From: [REDACTED] **On Behalf Of** CCD Planning Consultations
Sent: 09 July 2018 13:00
To: Planning.Responses
Cc: Roger Elkins; Anita Gardner
Subject: RE: Planning Consultation on: FG/105/18/PL

TO:	Arun District Council FAO: Mrs A Gardner
FROM:	Highways, WSCC
DATE:	09/07/2018
LOCATION:	Land At Asda Superstore, Littlehampton Road, Ferring, BN12 6PN
SUBJECT:	FG/105/18/PL Installation of a six-pump (12 filling position) automated petrol filling station ('PFS') & associated works. Resubmission of FG/206/17/PL.
DATE OF SITE VISIT:	n/a
RECOMMENDATION:	
S106 CONTRIBUTION TOTAL:	n/a

Figure 3.1 : Proposed PFS Layout (Courtesy of C+A Design)

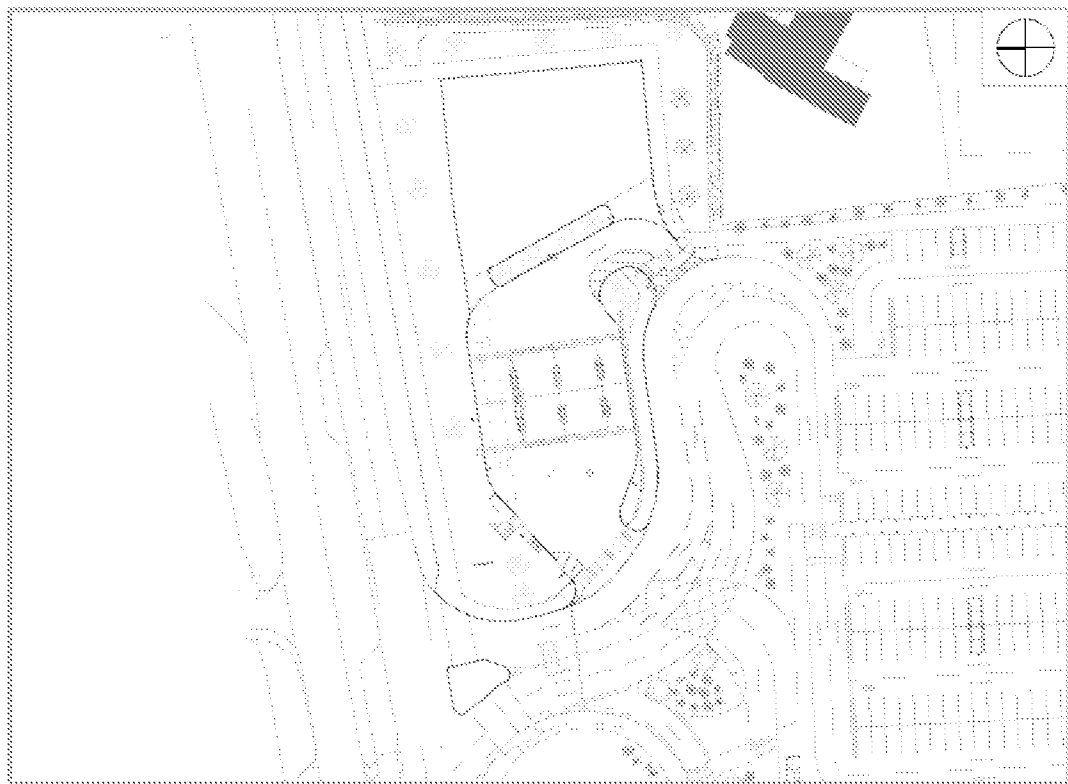
A Stage One RSA has been submitted in support of the application. Only one problem has been raised pertaining to pedestrian movements across the internal access point for the Petrol Filling Station.

It has been recommended that the footway at the eastern side of the access road between the signalised junction (A259) and along the frontage of the petrol filling station is removed and pedestrian are signed to the store via a footpath at the eastern boundary and the footway network west of the junction.

I note this footway link is still evident on the latest proposed plan (Rev D). The applicant should submit a signed Designers Response to the problem identified within the RSA, in line with WSCC's adopted Road Safety Audit Policy (Sep 2015).
